Recommendation: Approval

Applicant: Ms Lucy Coltman

Proposal: Erection of a new 1 bed, two storey dwelling - It forms a side extension to the west of 10 Reid Close

DRAWING No:							
PROJECT	ORG	ZONE	LEVEL	TYPE	ROLE	NUMBER	REV
1010	FCA	XX	01	PL	A	0111	P03

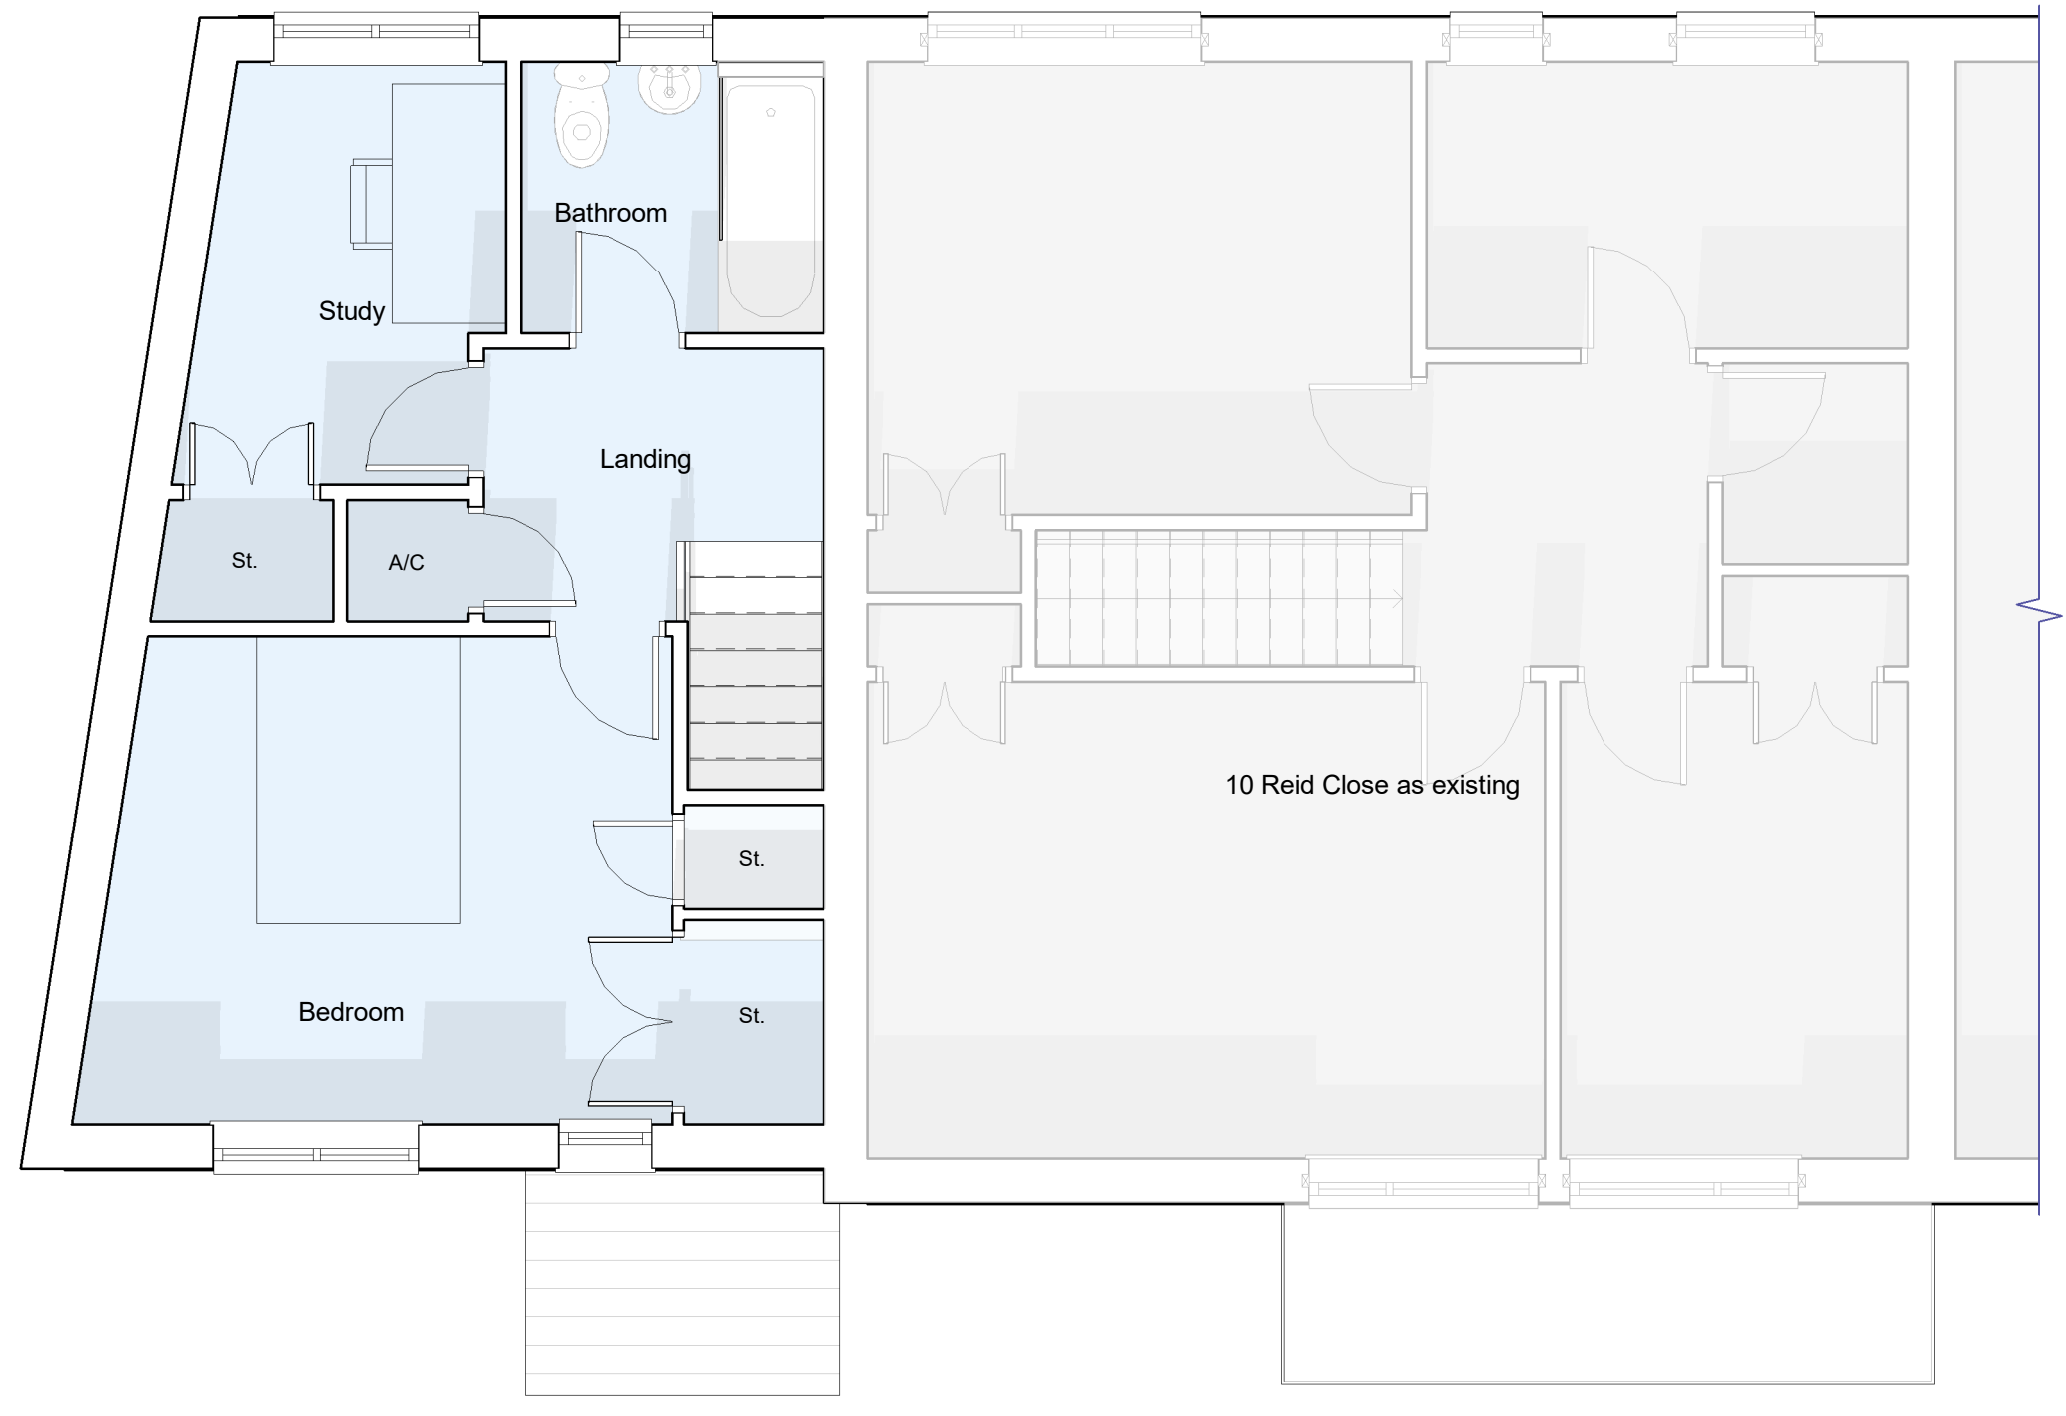
- 8.14. The proposals include the necessary internal facilities required for day to day living and also outdoor amenity garden space. Whilst the proposal would see a reduction in the garden/amenity area associated with 10 Reid Close it is considered that both the existing and proposed dwellings retain sufficient amenity space that it would not be to the significant detriment of the living conditions of either present or future occupants and not represent over-development of the site. In this respect it is considered that the proposals would provide an acceptable standard of living for potential future occupants and is considered acceptable in this regard.

2. Except where otherwise stipulated by conditions attached to this permission, the development shall be carried out strictly in accordance with the application form and the following plans and documents: Design & Access Statement, Planning Statement and drawings numbered: 1010 FCA XX XX PL A 0001/P03, 1010 FCA XX ST PL A 0011/P04, 1010 FCA XX 00 PL A 0110/P04, 1010 FCA XX 01 PL A 0111/P03 and 1010 FCA XX XX EL A 0310

DRAWING No:						
PROJECT:	ORG:	ZONE:	LEVEL:	TYPE:	ROLE:	NUMBER: REV
1010	FCA	XX	XX	EL	A	0310 P03

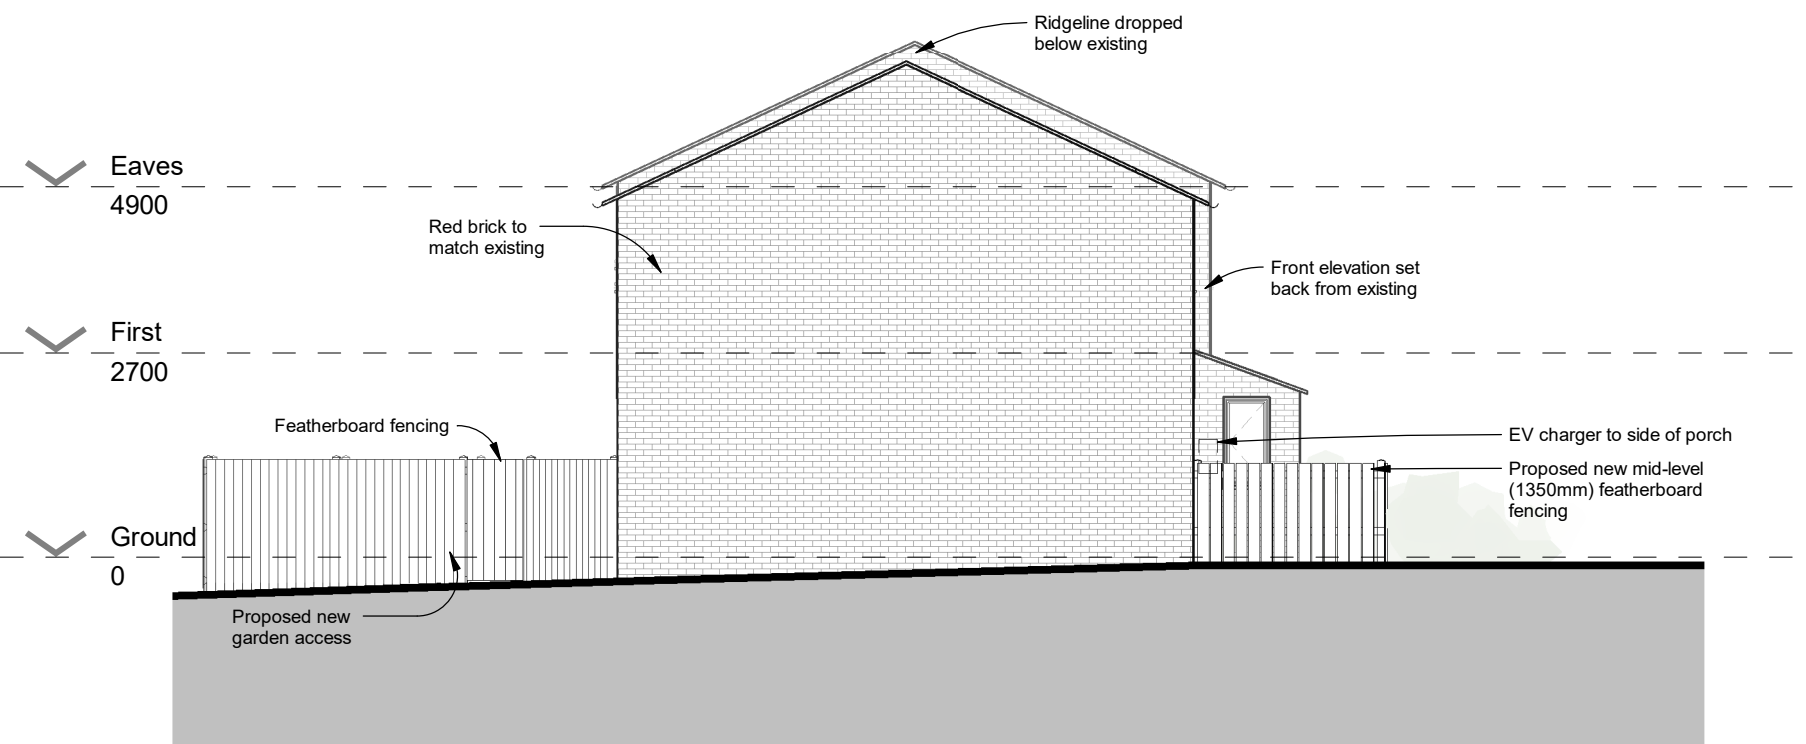
- 8.9. The existing street consists of brick and render, two-storey, semi-detached and blocks of terraced properties. Whilst the proposals would introduce a new dwelling unit, the design is such that it would have the appearance of being a subservient two storey side extension to the existing dwelling, replicating some of the design features present within the existing street-scene. The front elevation of the first floor would be set slightly behind that of the existing dwelling and the roof ridgeline would also demonstrate a degree subservience to the existing dwelling.
